***MODIFICATION REQUEST:
Wollongong Private Hospital
360-364 Crown Street and 9-11 Urunga
Parade, Wollongong (MP70_0070 MOD 1)***

- Modification to the built form, internal layout, service vehicle access and basement car parking of Wollongong Private Hospital

Director-General's
Environmental Assessment Report
Section 75W of the
Environmental Planning and Assessment Act
1979

November 2013

TRUE NORTH ↑	Drawn	Checked	Date	Scale
	CQ	HMC	03.06.13	1:500 @ A3
PROJECT NORTH ⊕	Drawing Title BUILDING EXTENT COMPARISON ELEVATIONS

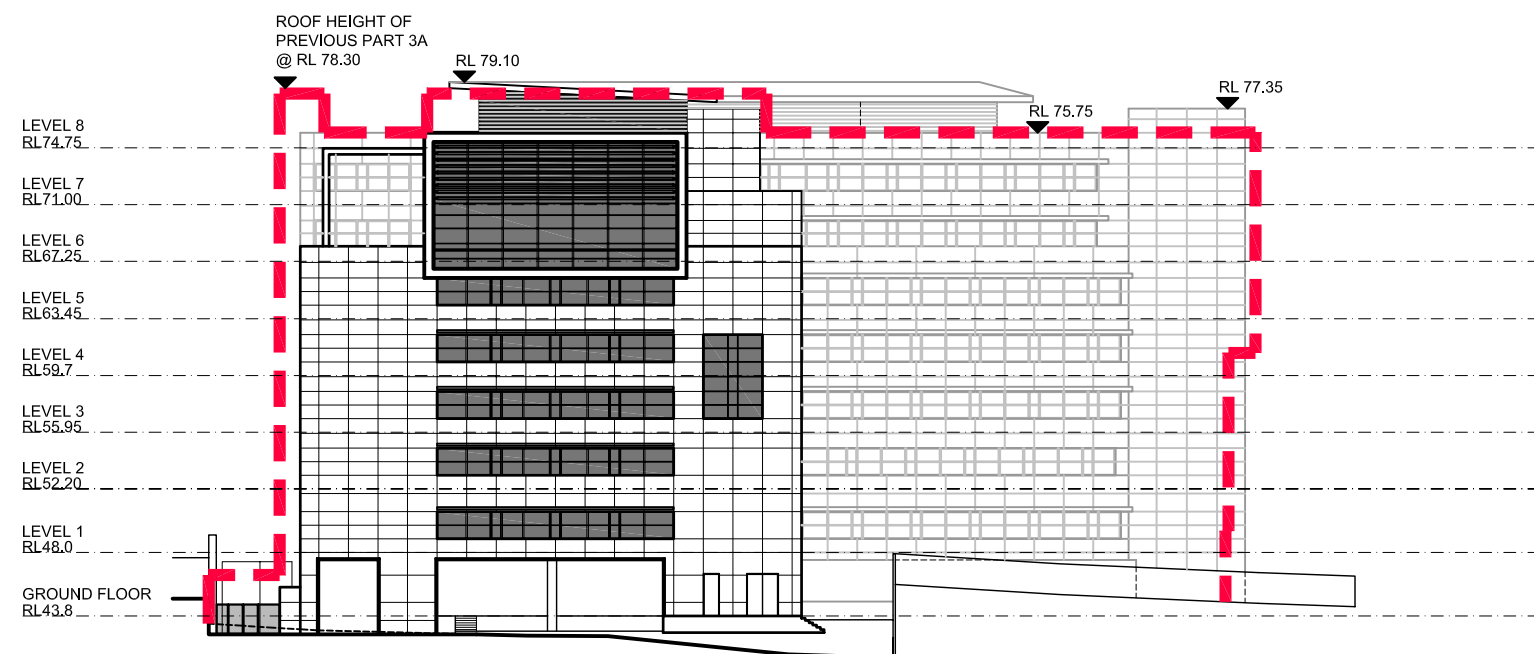
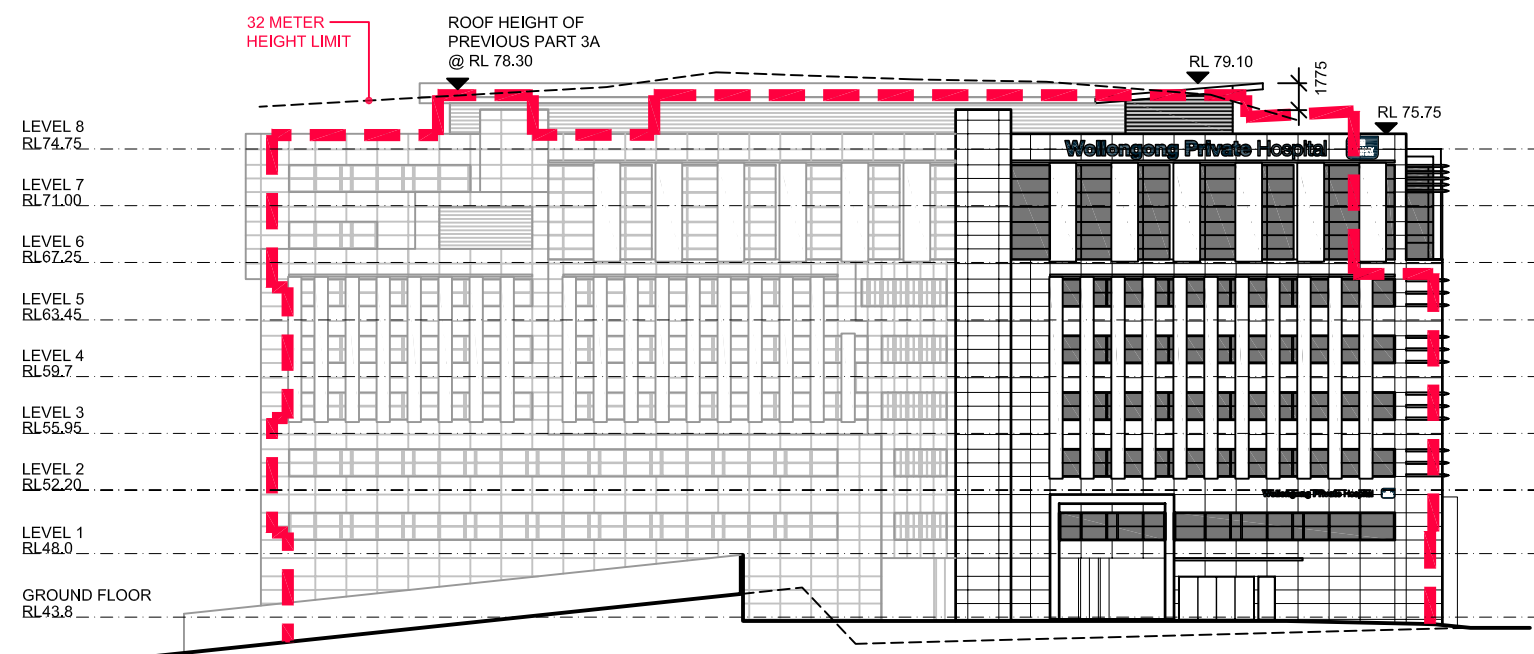
The scale of the amended building is generally consistent with the current approved design, although it is noted that a minor building height increase of 1.77 m above the 32 m LEP maximum height limit is proposed to accommodate the required floor to ceiling heights for hospital buildings. It is also noted that the top level has a reduced footprint which would also be recessed from the floors below, particularly from Crown Street. Notwithstanding, **Figures 10 and 11** demonstrate that the additional height is negligible in comparison to the original approved building (shown outlined in red).

T/S	Checked	Scale	Revision
PROPOSED OSD 'B' DETAILS	B.SHROY	A.Francis	SHOW @ A1
'Storm'tech' CHAMBER OSD SYSTEM	B.SHROY	A.Francis	SHOW @ A1

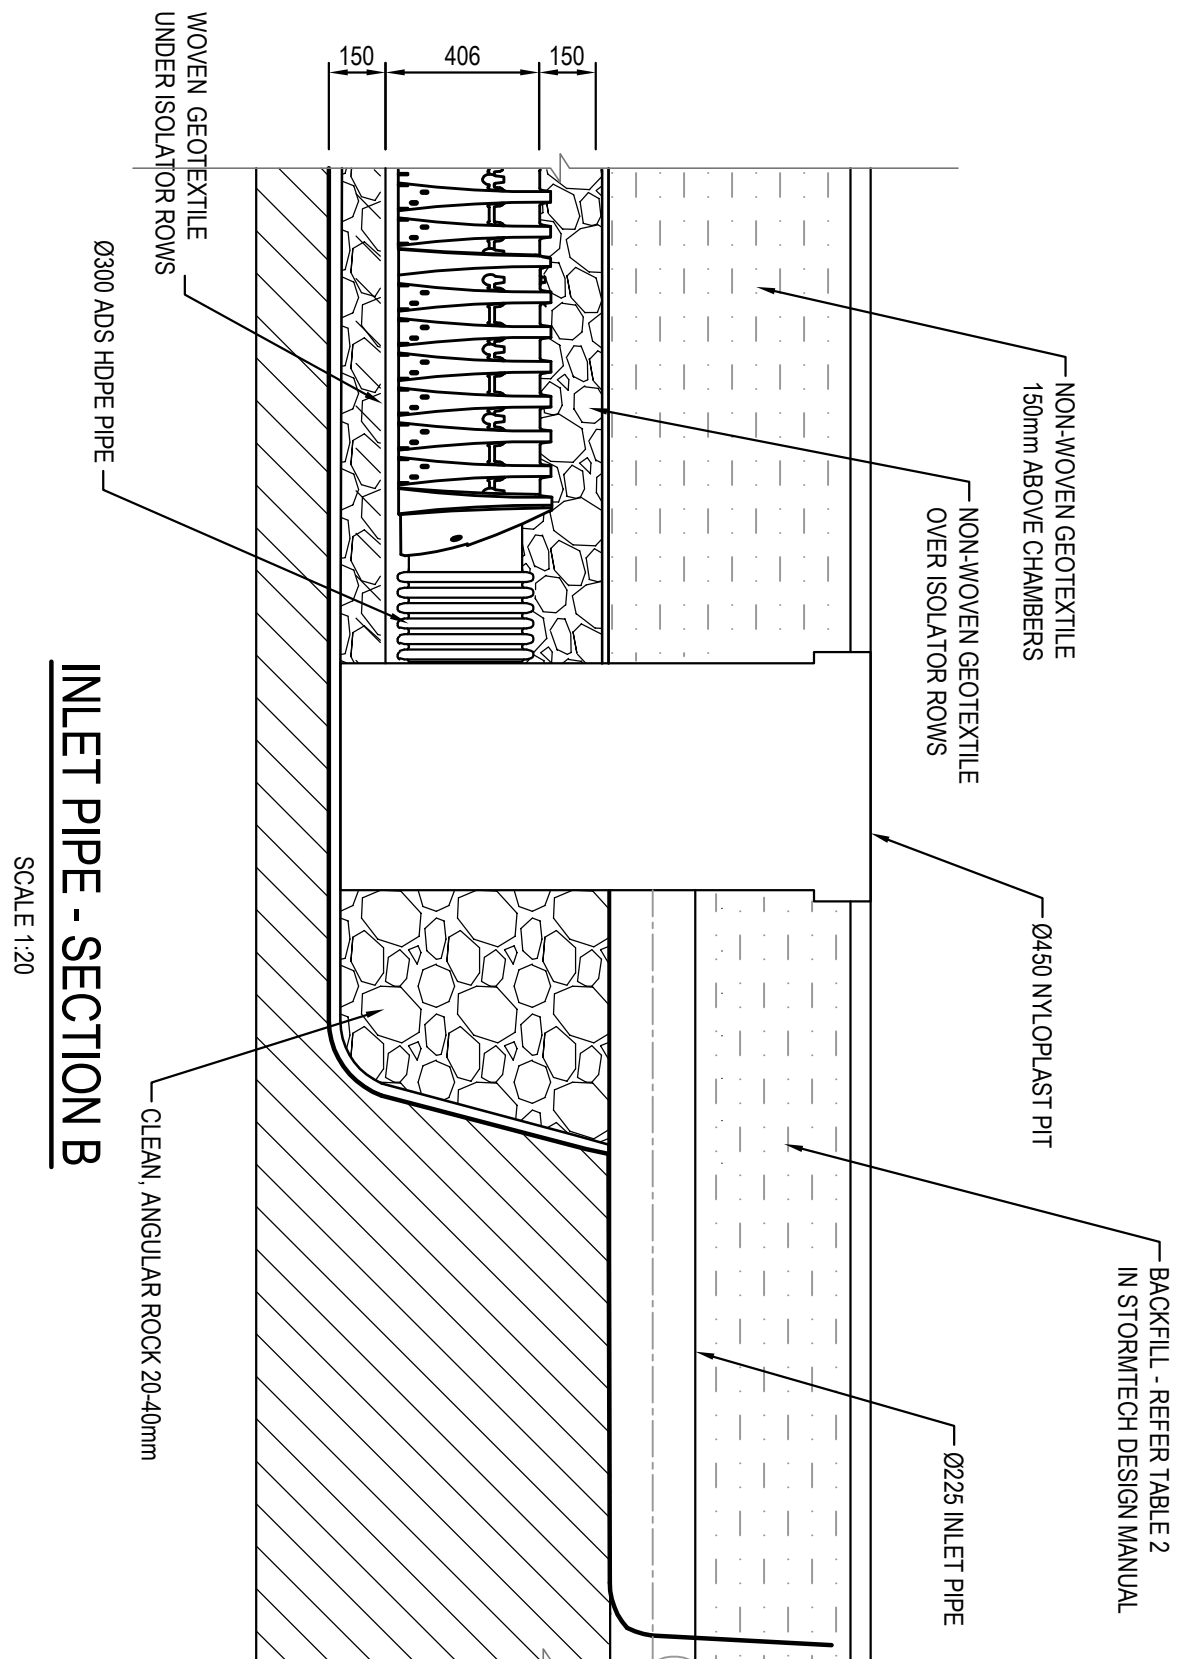
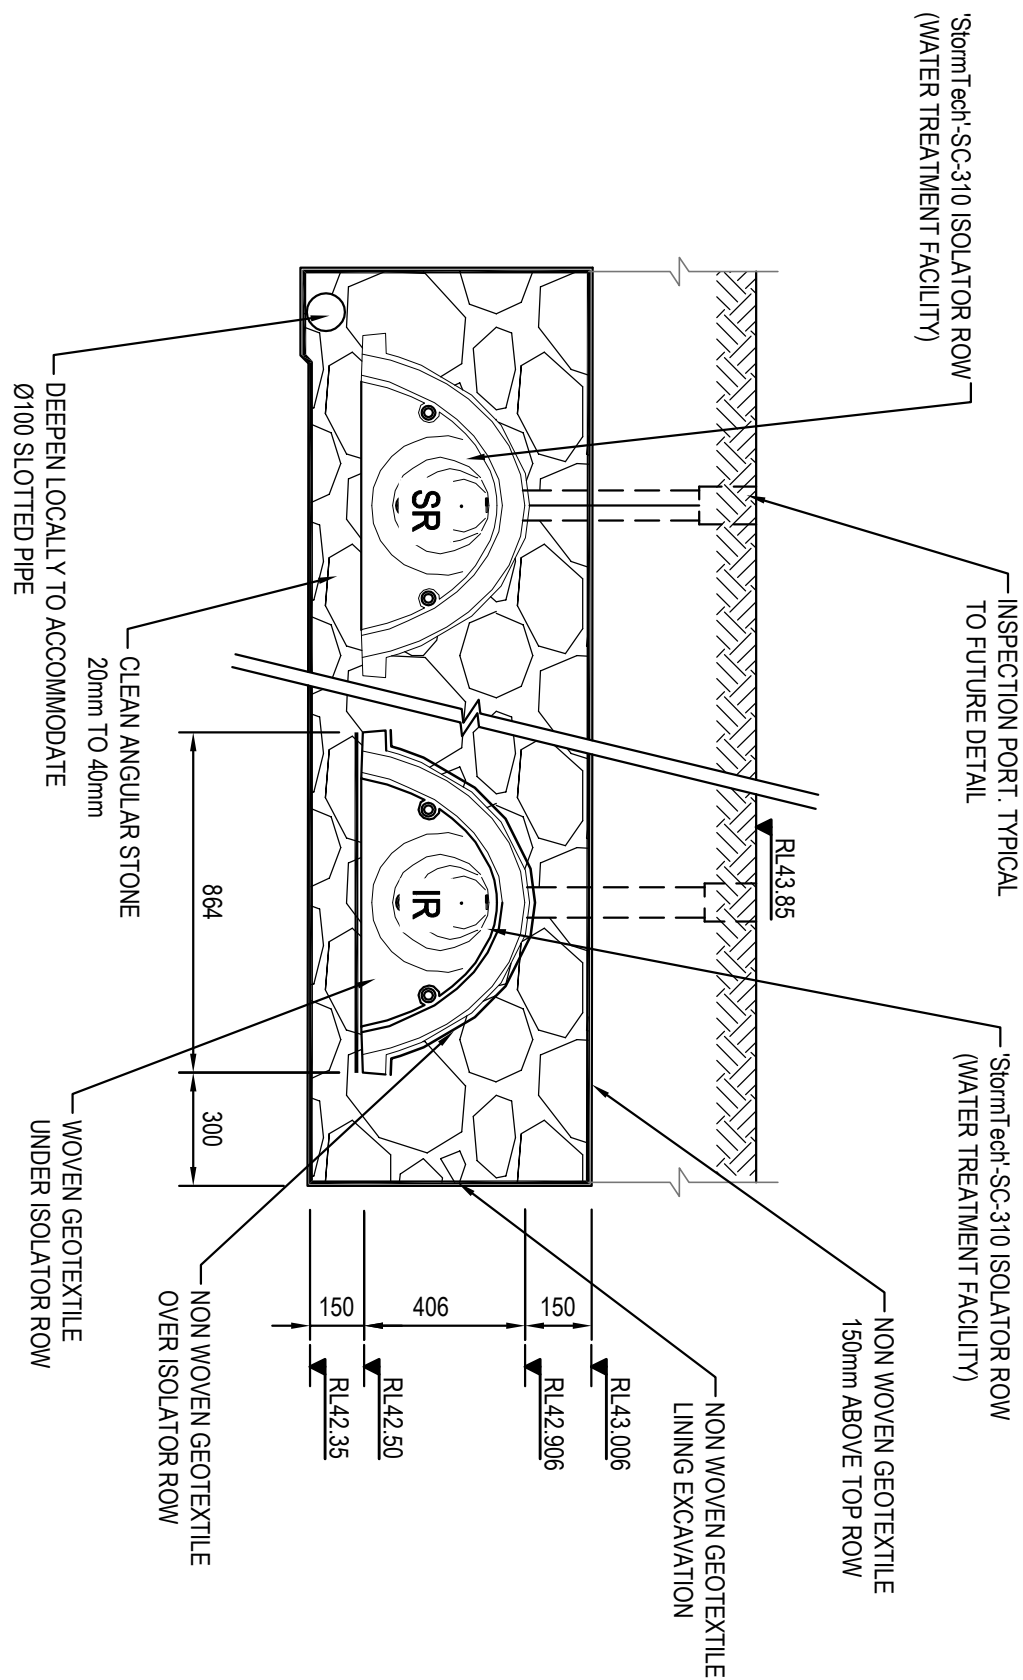
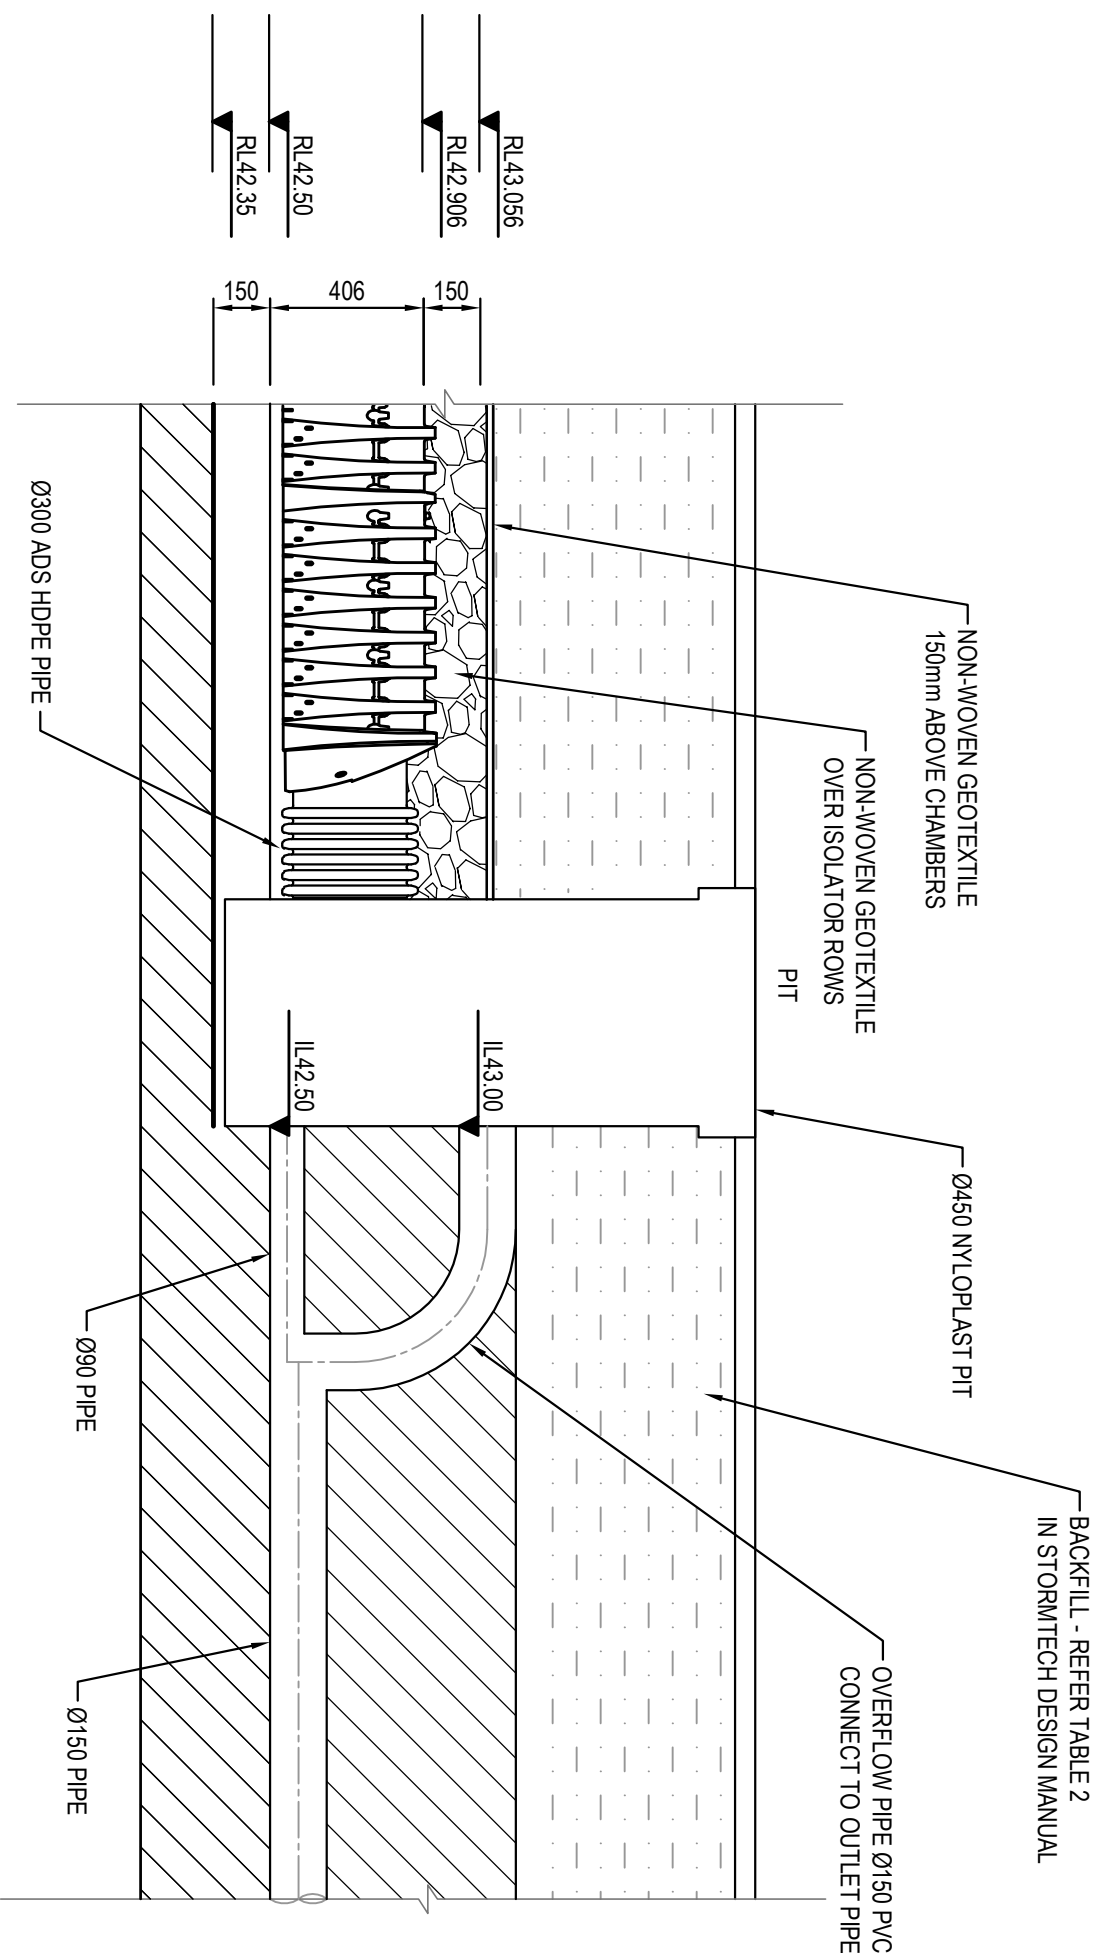
- an alternative stormwater drainage design is required for Catchment B and requested to be submitted to Council for further review; and
- the original s.94A contribution payable has reduced on account of the overall project costs having reduced.

- reinstate the Urunga Parade basement vehicle access as approved in the original scheme;
- provision of a landscape island in the middle of the driveway to break down the width of the driveway and minimise visual impacts along Urunga Parade;
- minor amendment to the service area waste room layout on the ground floor;
- amend the proposed business identification signage to reduce impacts, including the deletion of two Crown Street signs (No. 1 and 2) and amendments to the size of the rooftop signage; and
- revised civil/stormwater drainage plans.

MAIN HOSPITAL LOGO SIGNAGE - EAST ELEVATION

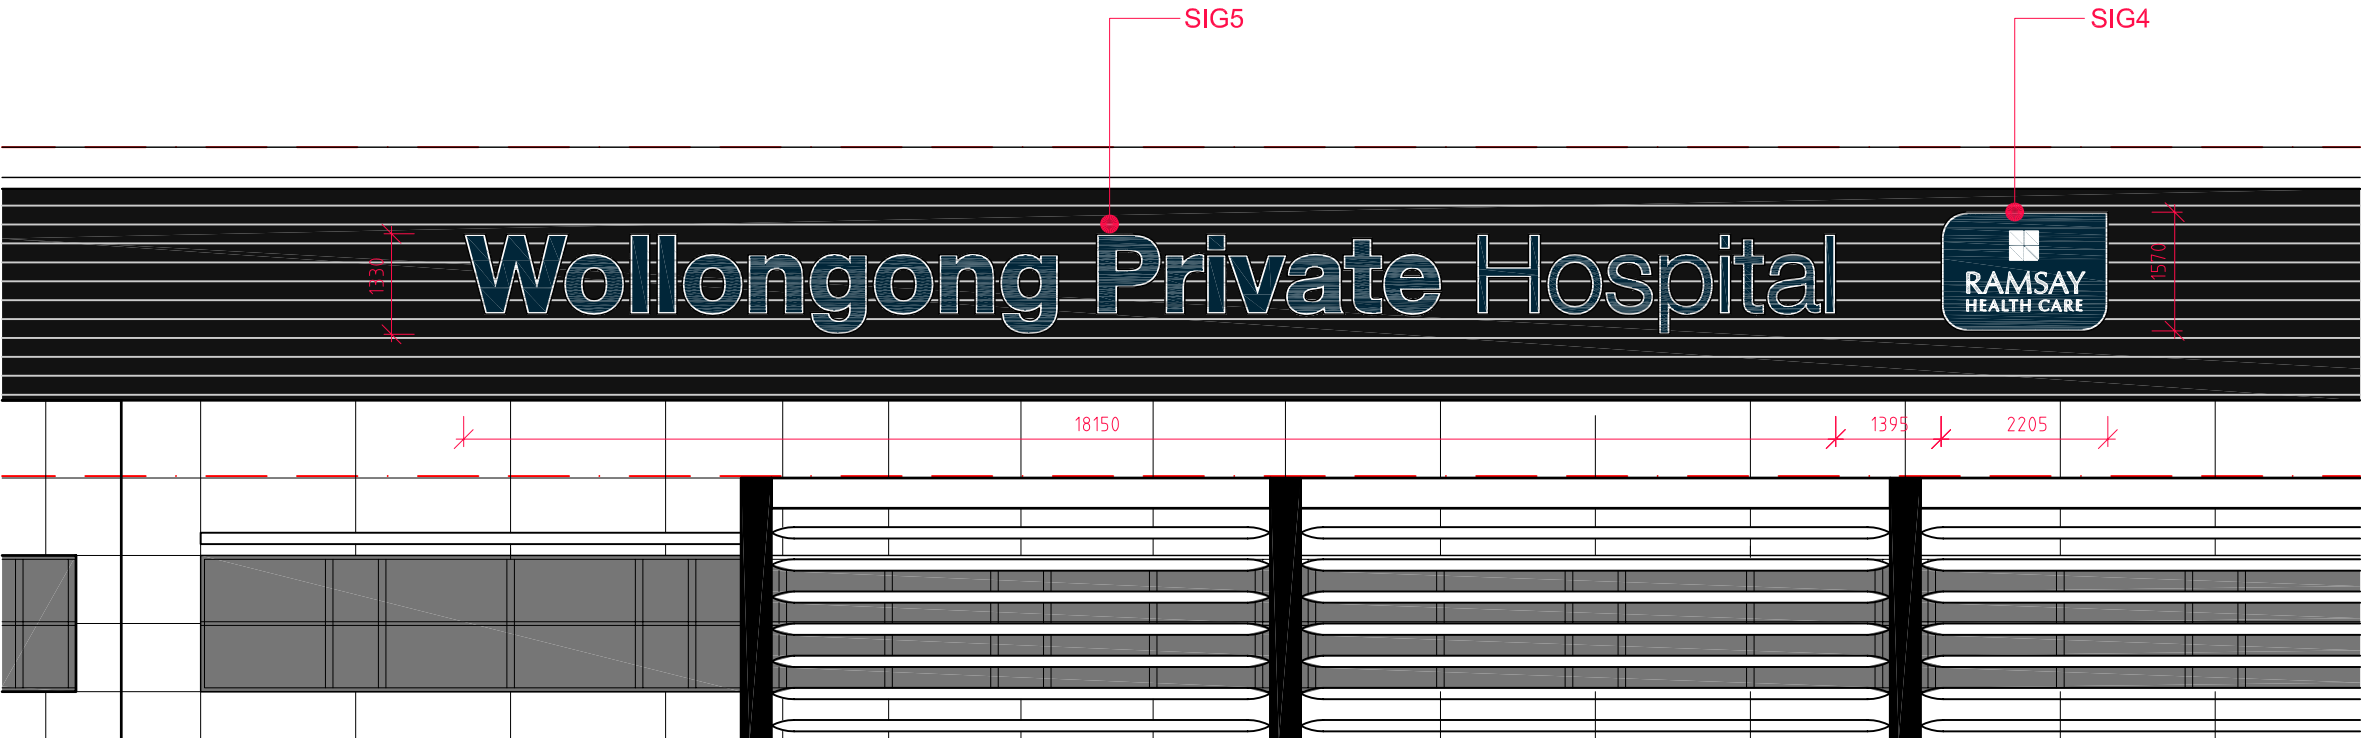
- due to the excessive number of signs, their size and design, it is recommended that the size of all the proposed signage be reduced by 50 per cent and all content be consistent;

Notwithstanding that no objections were raised by council with respect to the impact of the revised building design on the existing heritage item, council did raise concerns regarding the scale and visual prominence of the proposed new business identification signage and the impact the 'signage groups' would have on the townscape.

In response to these concerns, the department notes that the proponent undertook amendments to the proposed signage to minimise its visual prominence and impact on the surrounding townscape. In this respect, the scale of the signage groups, including the group located at the top of the western elevation (adjacent to the existing heritage item) have been reduced (by between 2.5 m to 3 m in width) and the signage proposed at the top of the building's Crown Street frontage has been deleted.

As exhibited, originally nine new business identification signs were proposed, though the proponent reduced this number to seven in response to concerns raised by council regarding their potential visual impact and prominence within the local townscape. In addition to removing the larger signs from the Crown Street elevation, the area of the major signage

zones at the top of the western and eastern elevations has been reduced by between 7 sqm and 10 sqm by reducing the scale of each respective sign. The amendments assist in reducing their prominence within the townscape, but maintain the role of communicating WPH within the health precinct.
